RIBBLE VALLEY BOROUGH COUNCIL

COMMENTS ON APPELLANT'S STATEMENT

Planning Inspectorate Reference:	APP/T2350/W/23/3322801
LPA Application Reference:	3/2022/1180

Pinfold Farm, Preston Road, Ribchester, Preston PR3 3YD

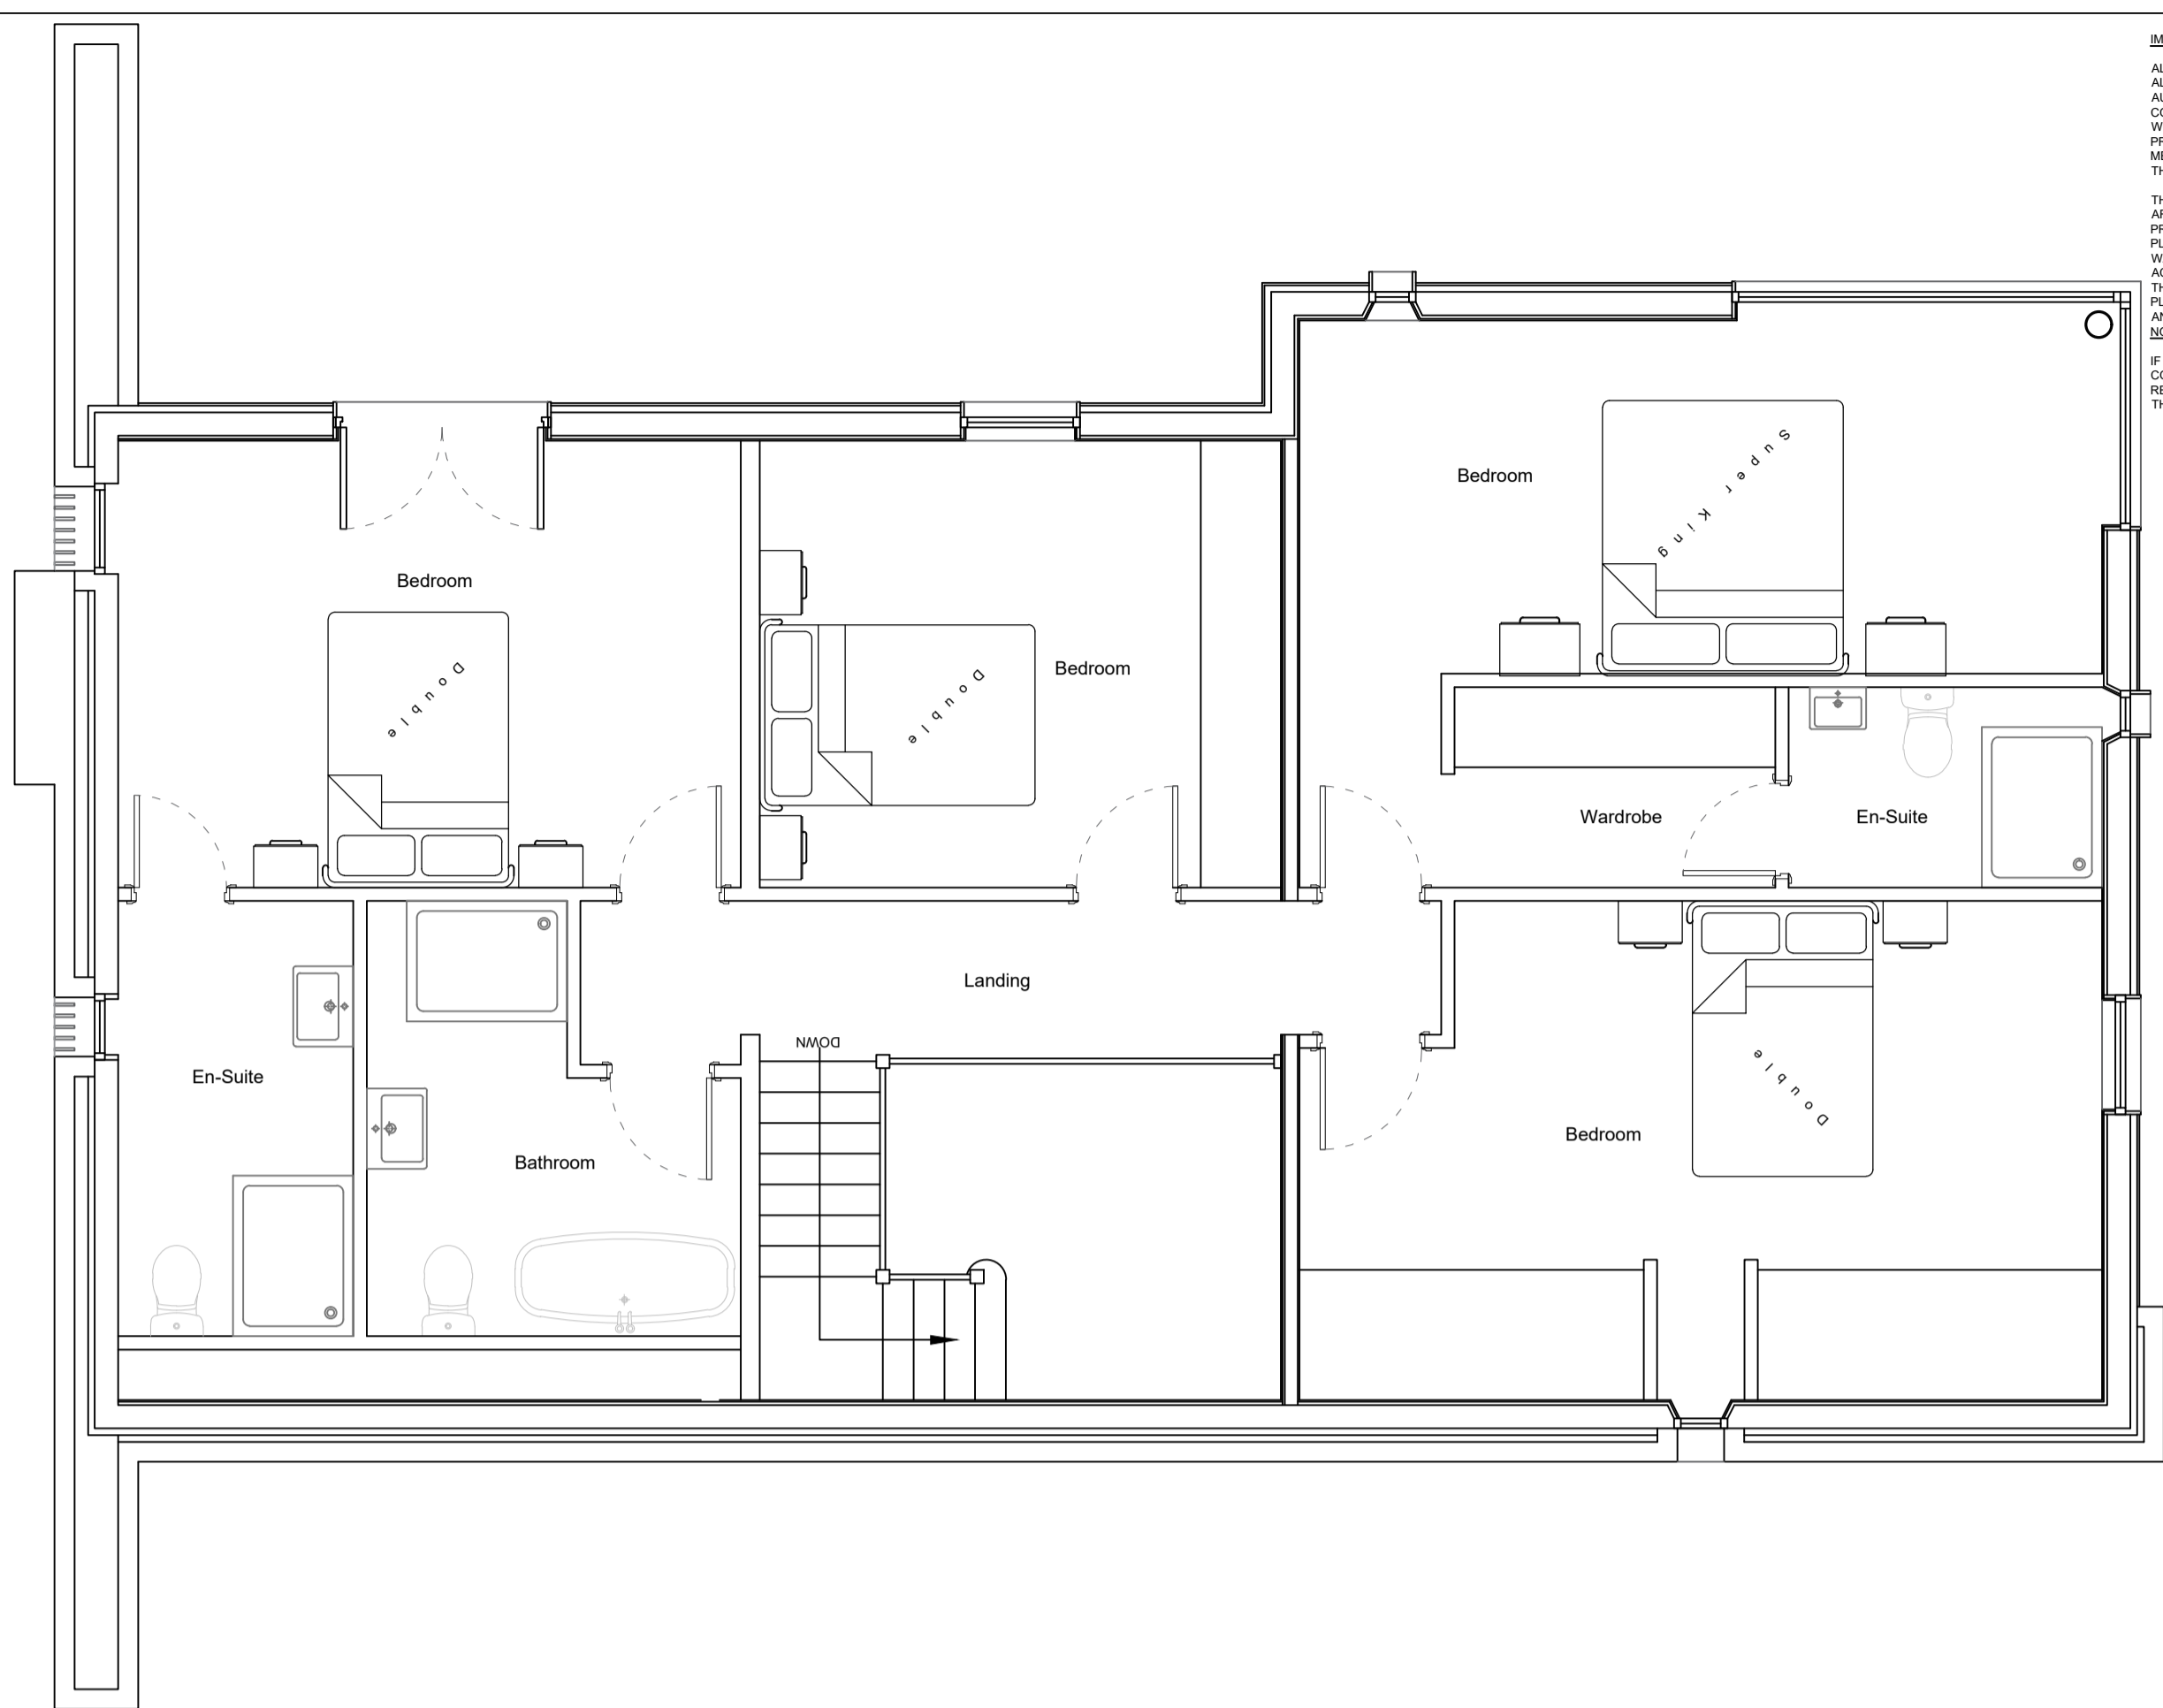
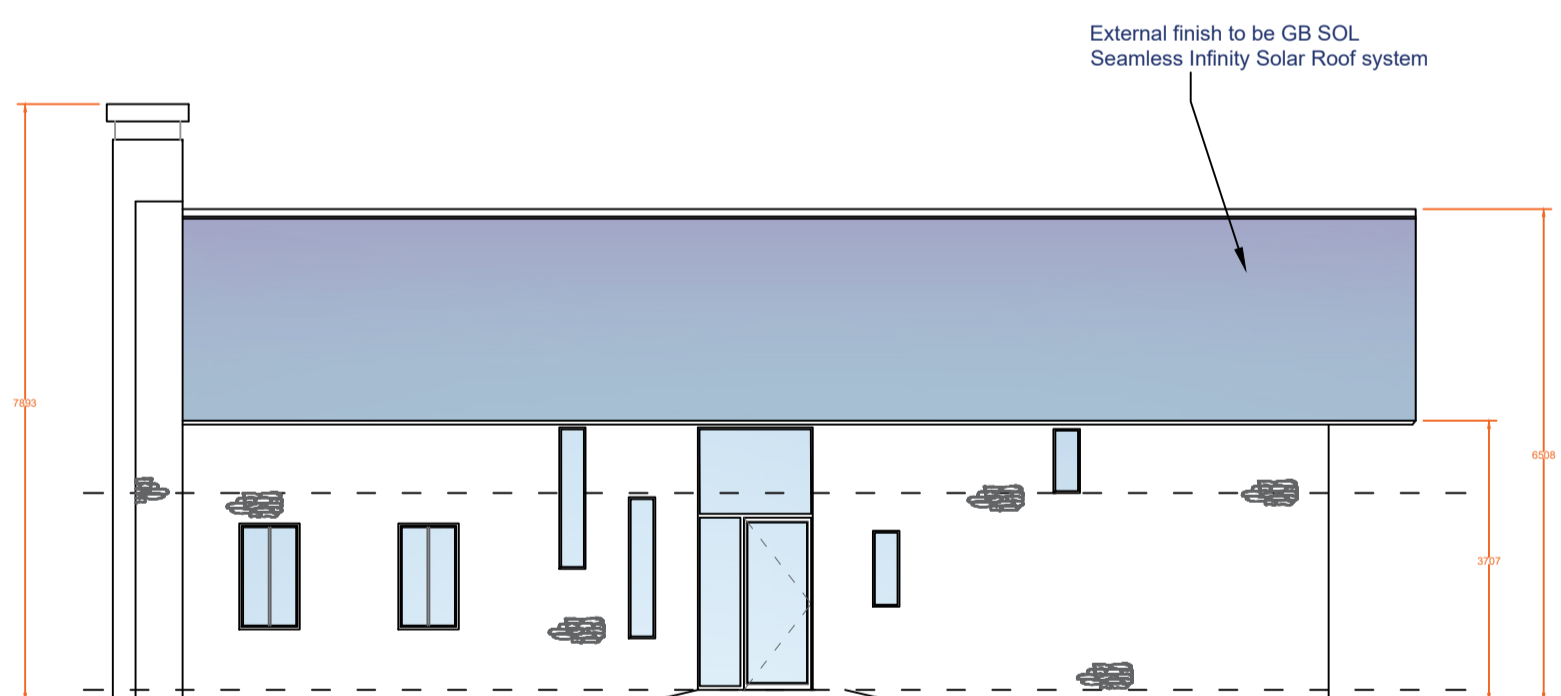
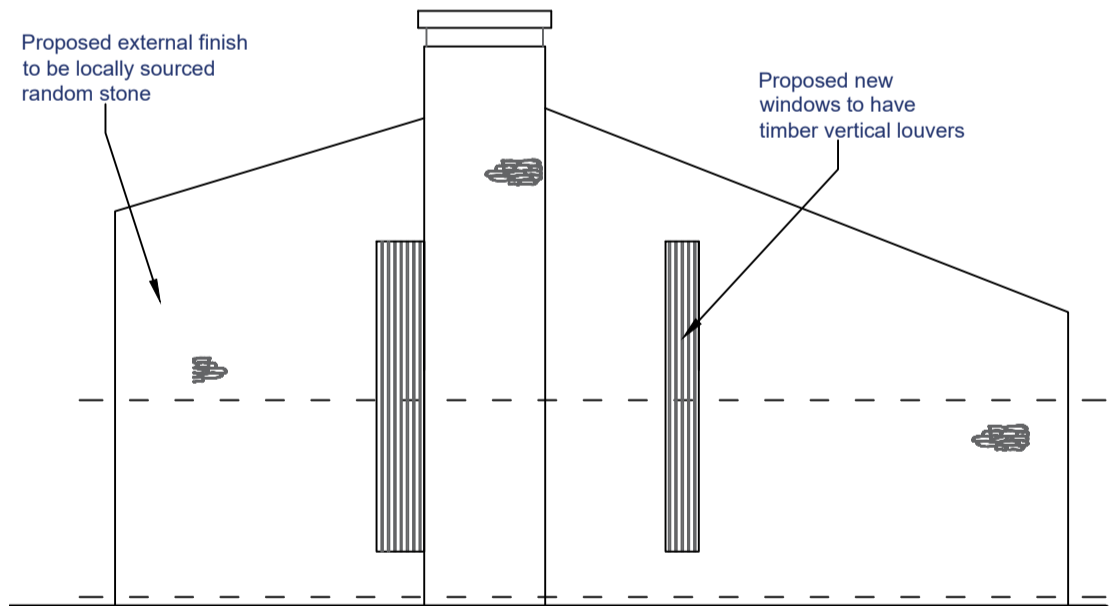
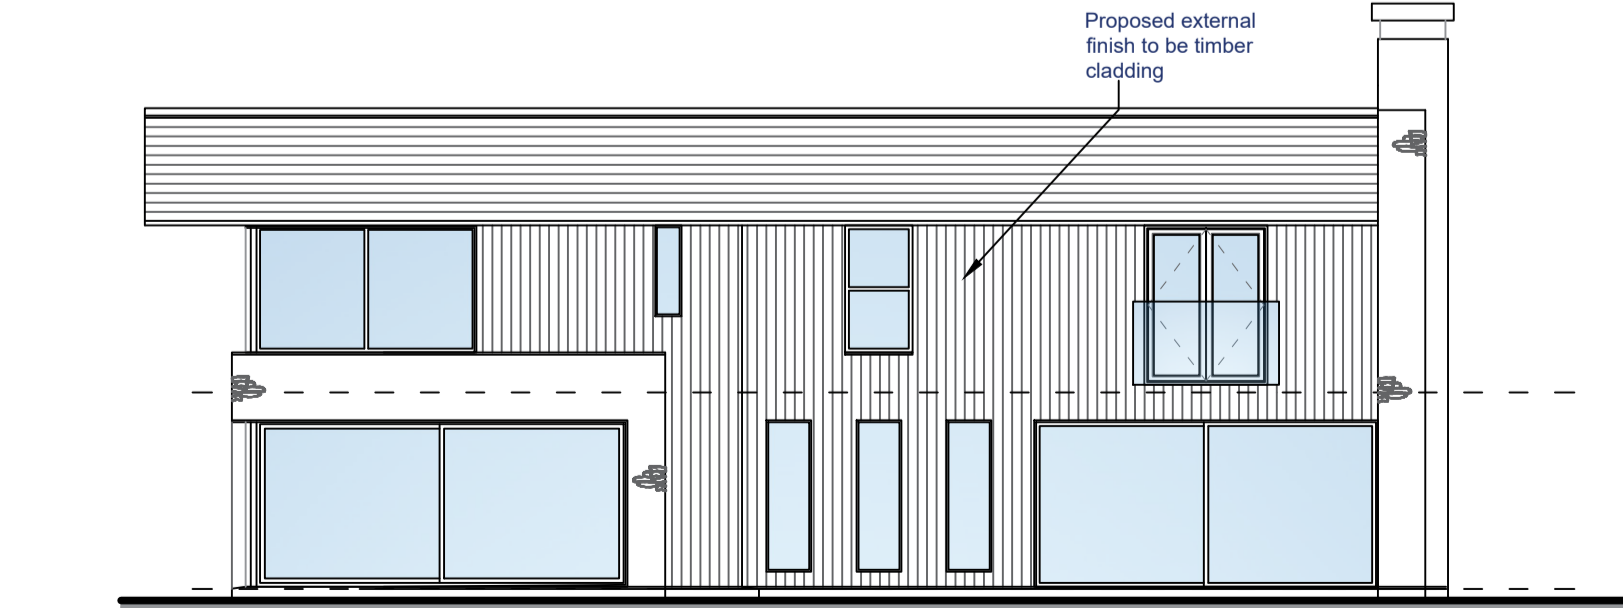
- 1.5 Contrary to the above, the proposal represents a new building in its entirety, of a different massing and roof formation to the existing barn, and with a design and external appearance that bears no resemblance to its agricultural origins which it is seeking to replace. The Delegated Report (Appendix 3) expands on the concerns regarding design and visual harm, noting that the proposal would result in an incongruous form of development with a more prominent orientation and associated domesticated appearance resulting in harm to the character, appearance and visual amenities of the area.

**Proposed Site Plan**  
Scale (1:200)

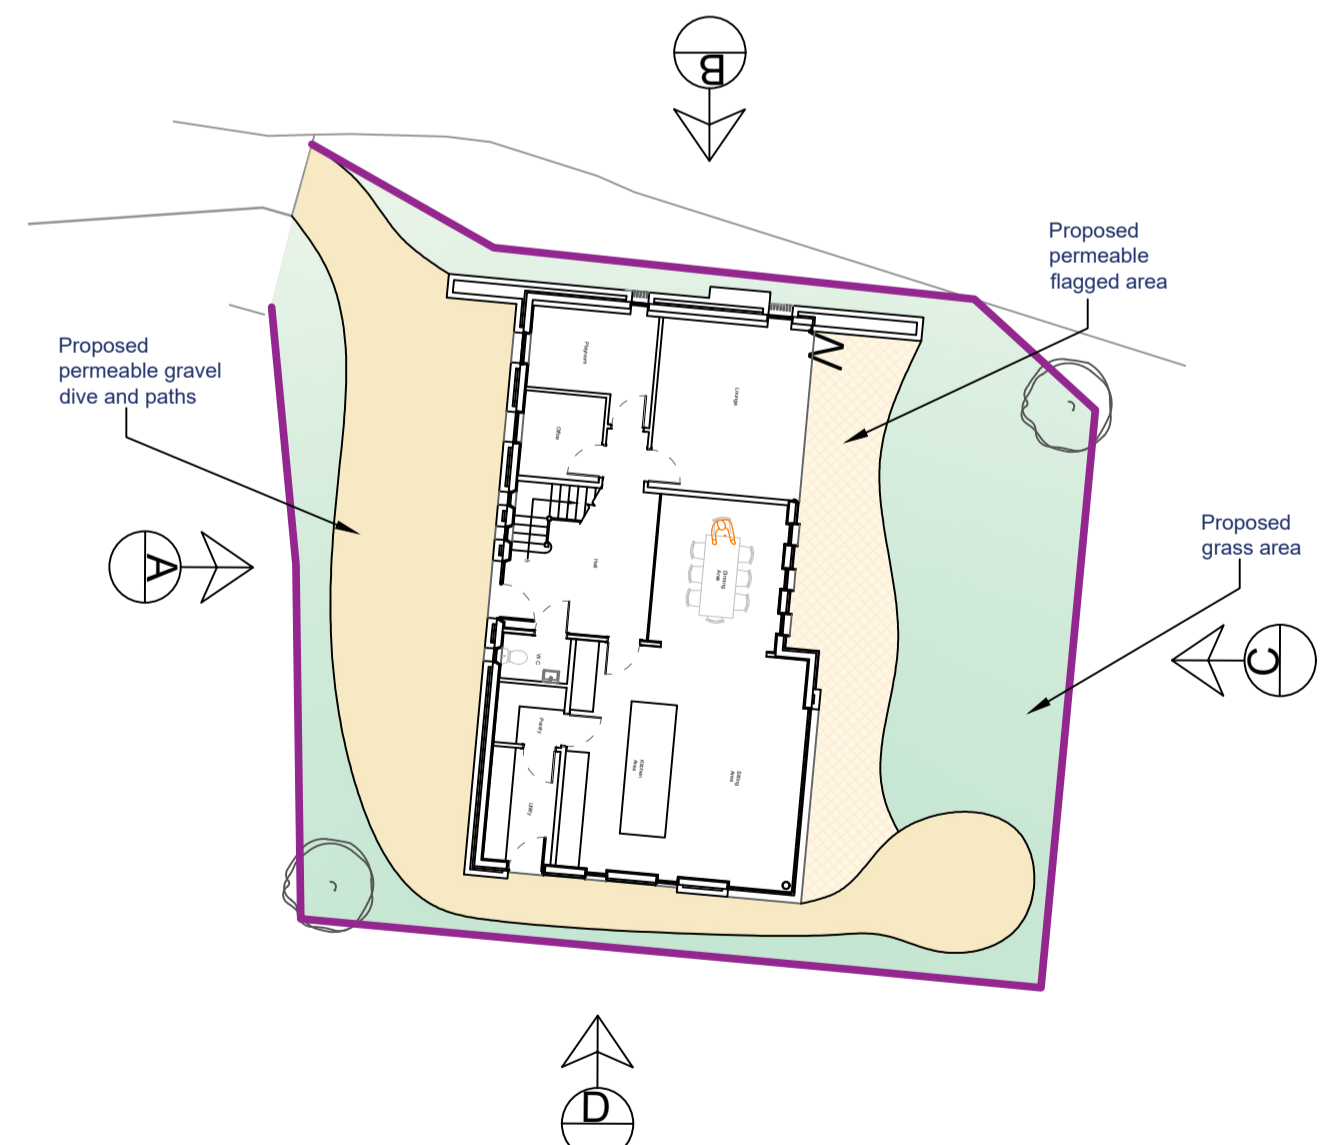
- The Appellant states that the proposed scheme would result in a reduction in the hardstanding, however, it would appear from the submitted site plan 009 that this hardstanding would likely become residential curtilage immediately to the east of the property, and therefore be subject to domestic paraphernalia which would have an urbanising impact on the countryside. Therefore the Council does not consider that this would be a benefit.
